Riverview

Following up on my phone call.

Drawing Name:	Lot 2 Site, Utility, Grading and Drainage Plan
Project:	Riverview Street Lots Portland, Maine
Client:	Diversified Properties P.O. Box 10127, Portland, Maine 04104

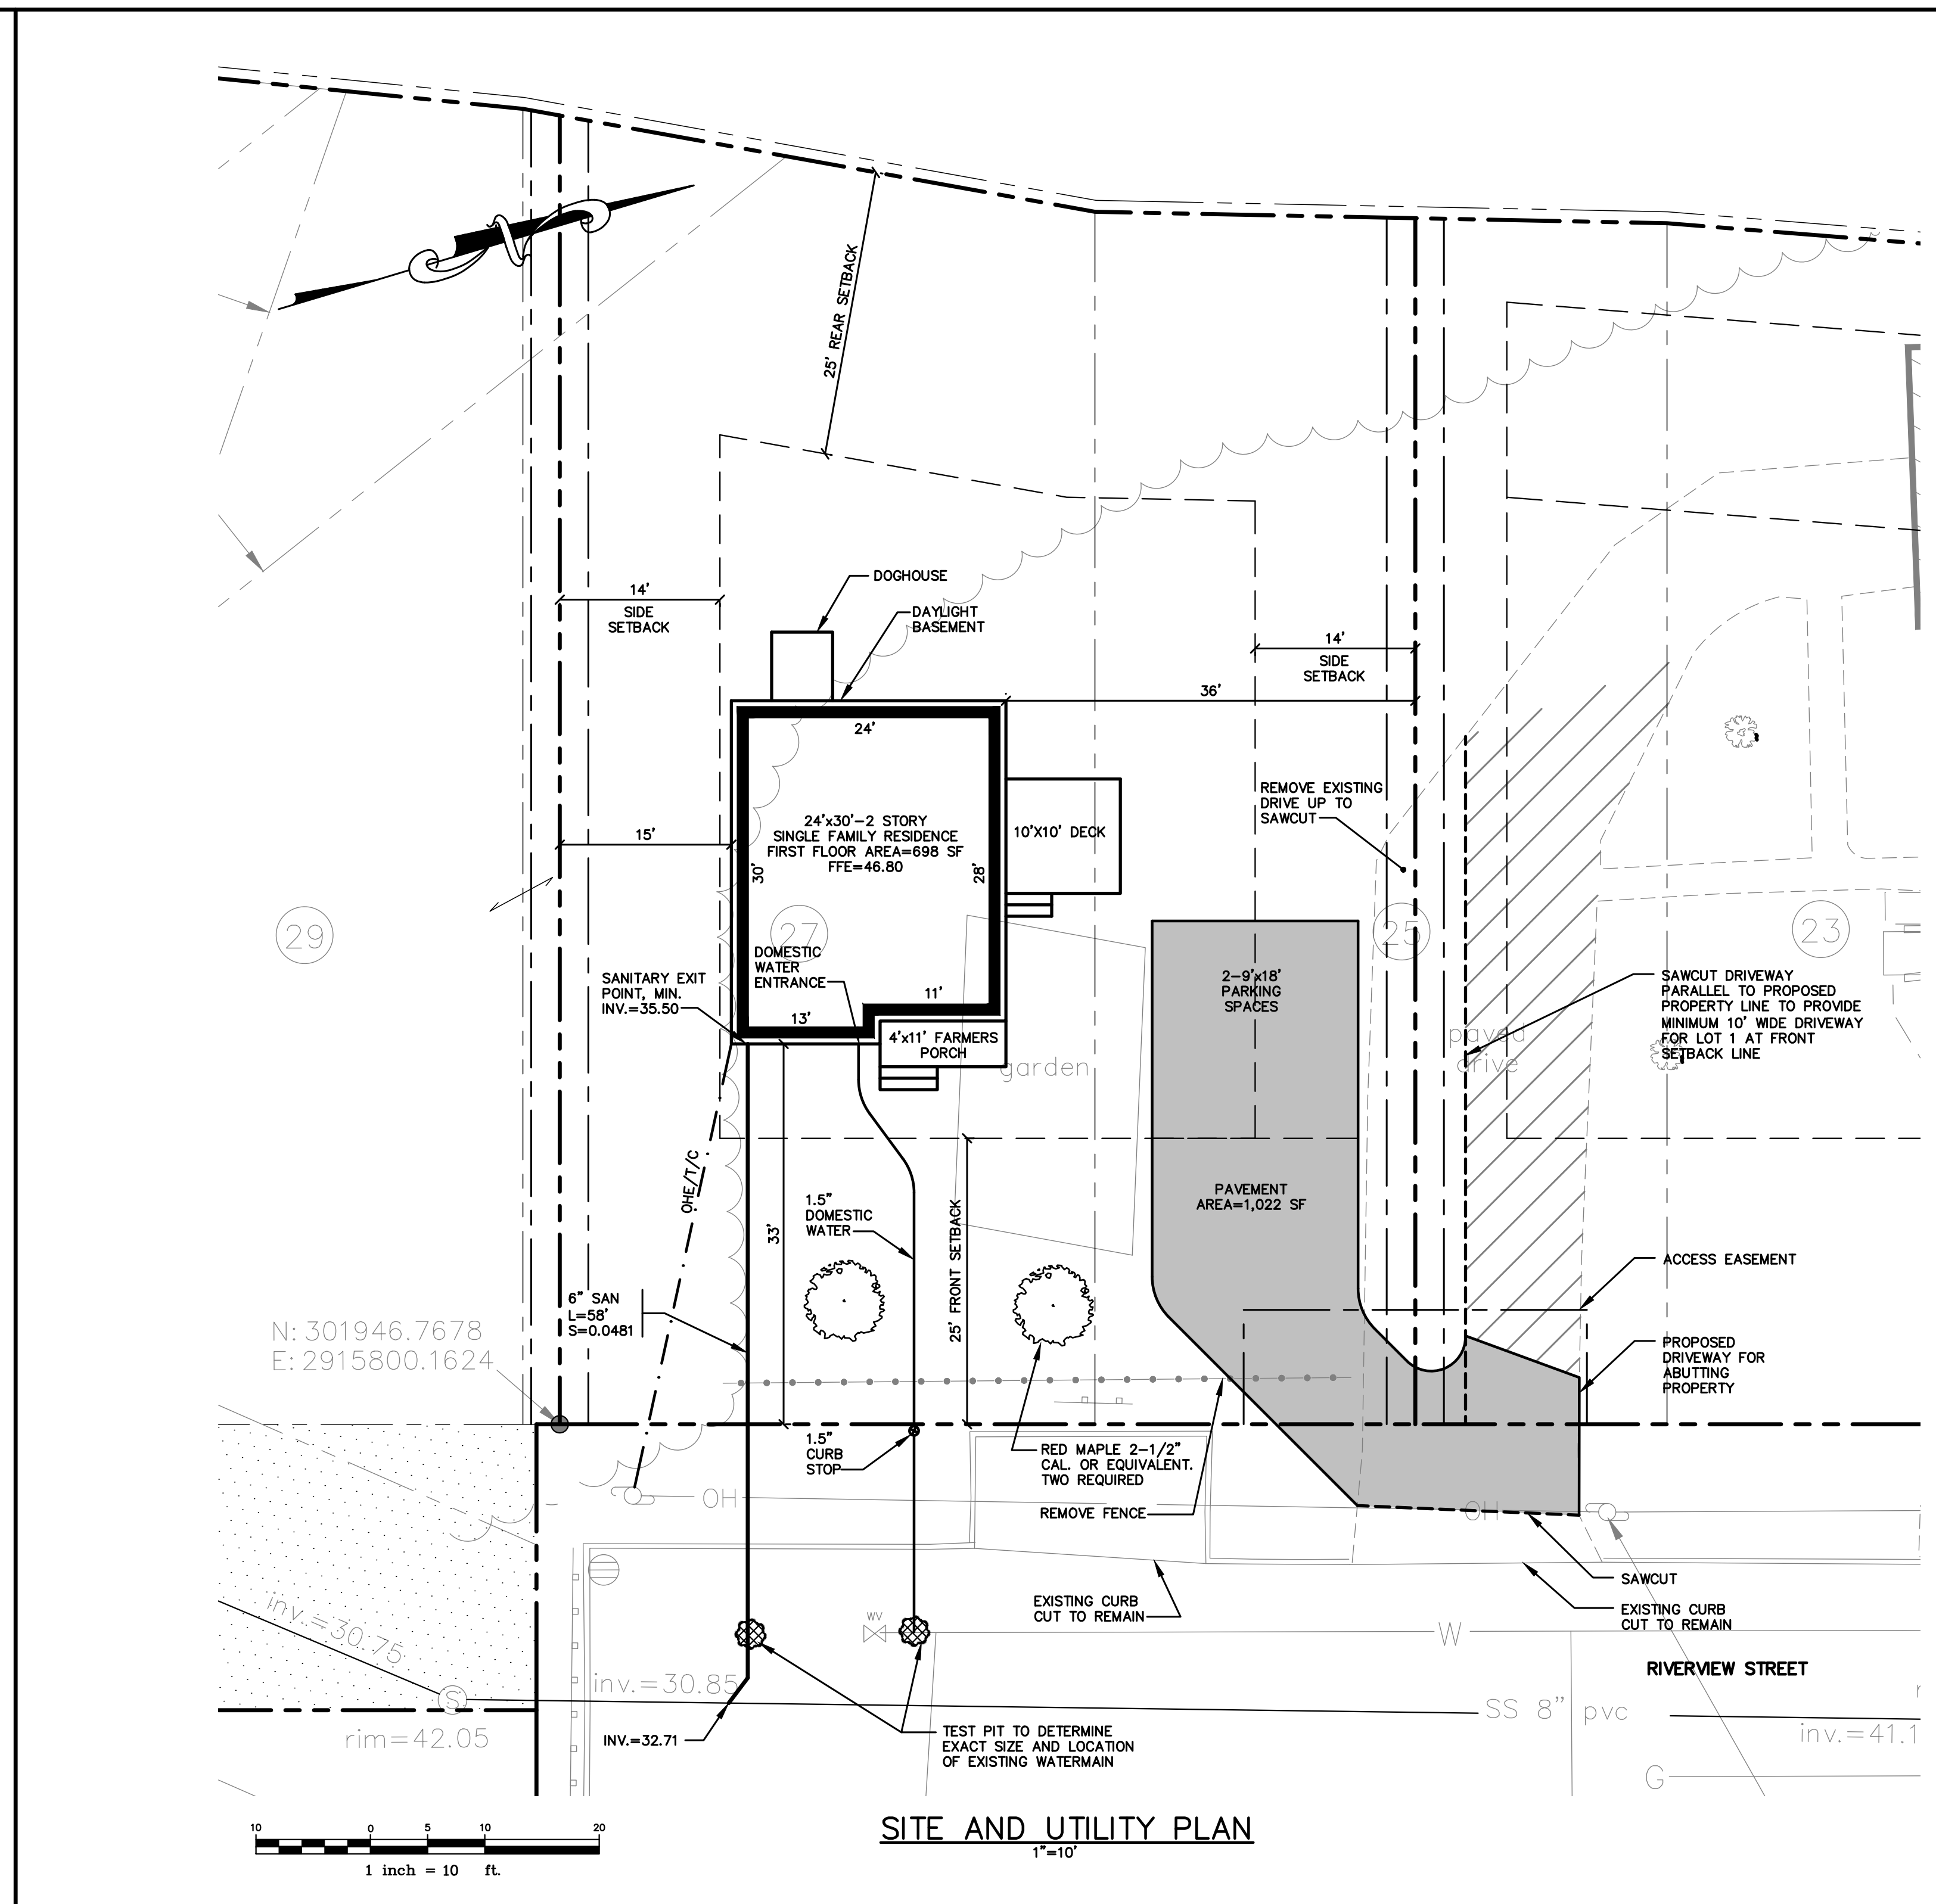
Thanks for the plan from Doug Reynolds. Besides just the rip rap area, there was more area that was disturbed beyond what was shown on the original site plan. I would like to have Doug locate the original line for disturbed area to show all the parts that were cleared beyond just the rip rap.

Once that is determined, you need to submit a replanting plan for all the area that was disturbed beyond the original line for disturbed area. The replanting plan should include the species that are being planted and the number of plants.

As far as the area that you need to replant beyond just the rip rap, have Doug Reynolds overlay the original line of disturbance with the actual line of what was disturbed.

You never submitted a plan that shows the exact area of the lot that has been cleared, so it is difficult to provide any firmer guidance. You submitted one that shows the rip-rap extent, but it appears that there was clearing beyond the rip-rap. We need a plan that shows exactly what is currently cleared. Ann requested this from you back in October and it does not appear that you ever submitted it.
